From: Tim Townsend [REDACTED]
Sent: 18 May 2017 09:11
To: Planning.Responses
Cc: Claire Potts; Julie Bolton
Subject: Landscaping comments - LU/121/17/RES

Please find below, WSCC comments in response to landscaping for the above development. This should be read alongside previous WSCC highways response dated 15th May 2017.

Shared / private driveways:
Marshalls block paving, Bracken colour

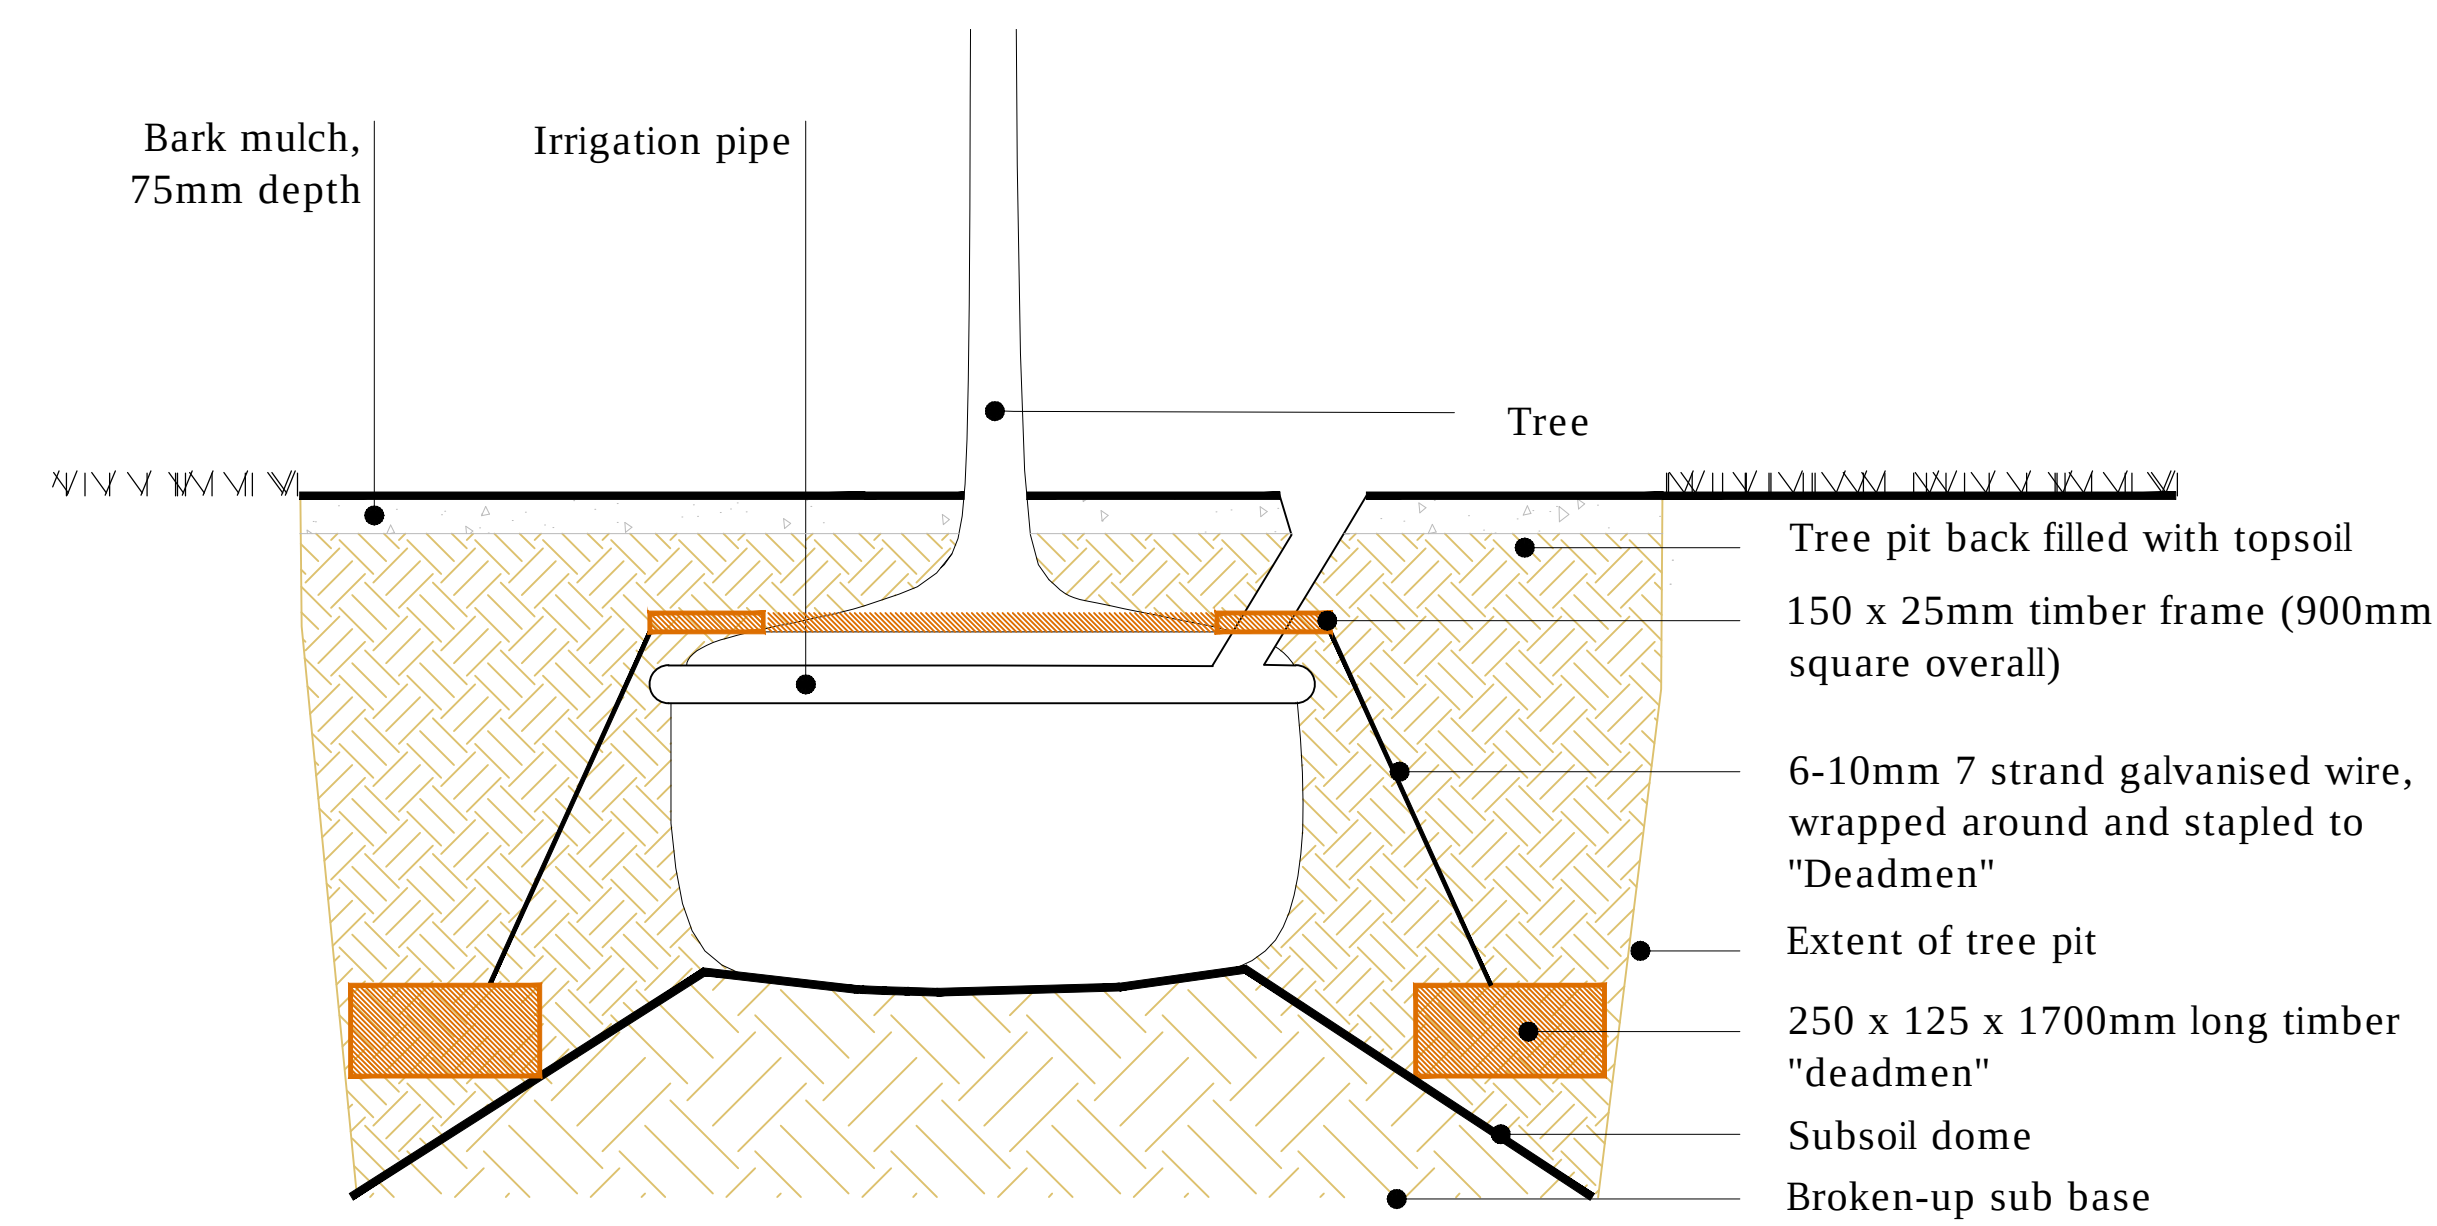
It is noted that to the south of 'Main Avenue', future development is likely to be 3 or 4 storey apartment blocks – this may preclude a continuous verge depending on access points, however, a continuous verge [or as continuous as possible] is far better for successful tree establishment / long term survival than individual planting locations. Ideally, the buildings should be set well back from the footway edge to give good separation between the building elevation / fenestration from trees, thus preventing future requests for removal / reduction. If there is a continuous verge, then there is no need for granite sett edging and tree grilles which will require maintenance and may become distorted through incremental growth or the grilles may damage the tree if left in situ for too long. Usually there are section / plan drawings showing the tree 'pit' details, e.g. irrigation system etc. Stakes / ties are indicated instead of ground anchors for trees of this size which is unusual/surprising – please explain.

Car park – the birches are shown in individual ‘pits’ with grilles and granite sett edging. It’s not clear what the surface is between each tree but if it is a hard surface only supporting low frequency pedestrian traffic, it should still be possible to have a continuous rooting environment underneath; soil cells may be needed to support the hard surface. Alternatively a continuous grass verge would be better – no need for grilles / edging. Will there be any bollards, knee rails or other ‘barrier’ to prevent cars damaging the tree stems? I note the trees are shown located between spaces but it is still possible.
